AB/63/19/PL

The Old Warehouse is located on River Road and fronts directly on to the River Arun. Unlike the other properties in the street, this building was constructed in the 1970's and plays a striking feature on the street-scene.

I note that previous applications have been granted to alter some of the windows on the building. The proposal is for the creation of a new opening for a private front door to one of the apartments. The elevation affected by the proposal is simple in nature with limited windows present. The new door opening will introduce another opening on to the road. It is considered that this will have a neutral impact upon both the building and the character of the local area. This is on the basis that the door reflects the existing windows/doors on the building. Further, it is considered that the introduction of an additional opening will not harm the significance of the neighbouring Listed Building.

Proposed Front Elevation

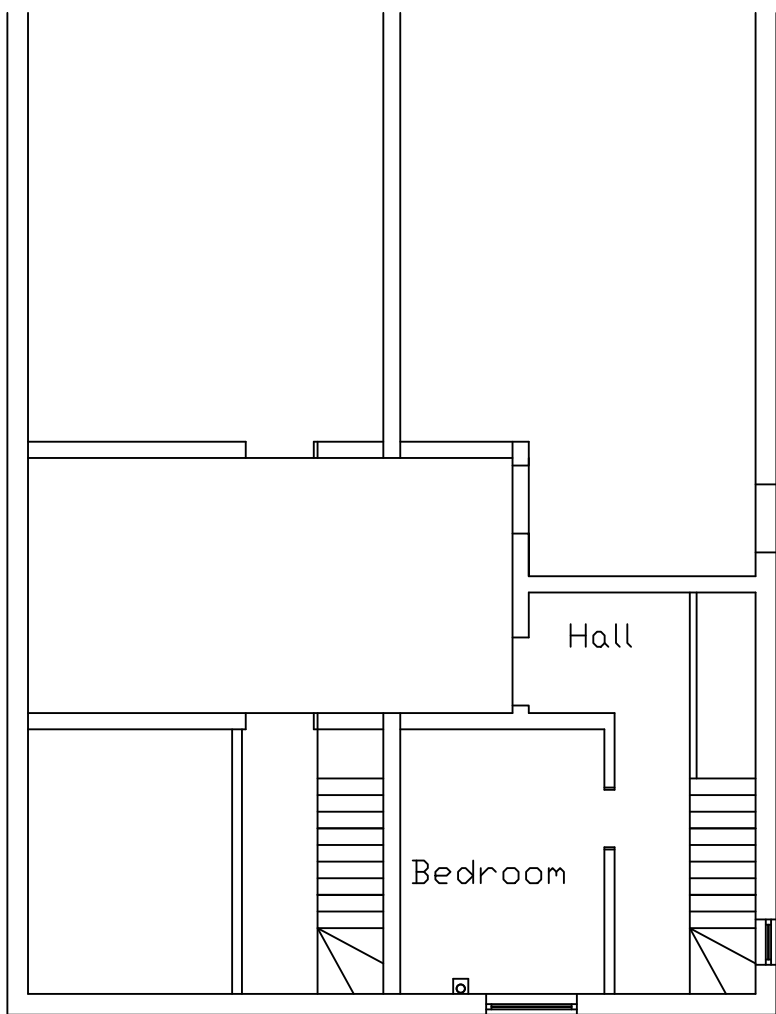
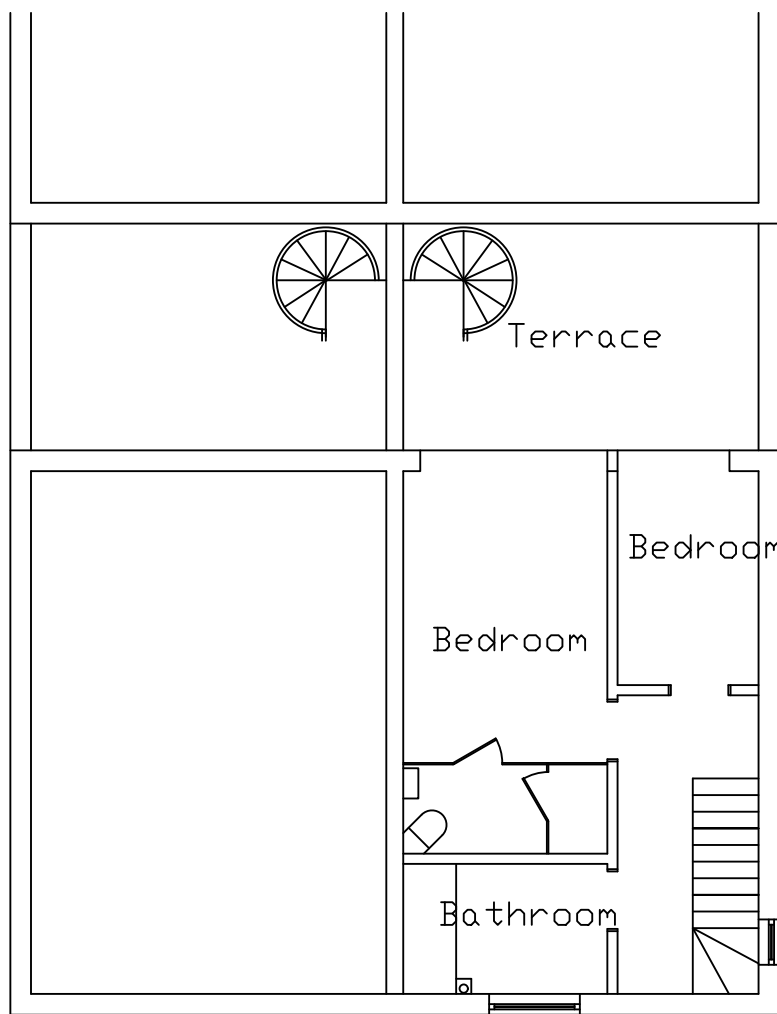
If you are minded to approve the application, details of the door should be provided to the Local Planning authority (LPA) via a condition.
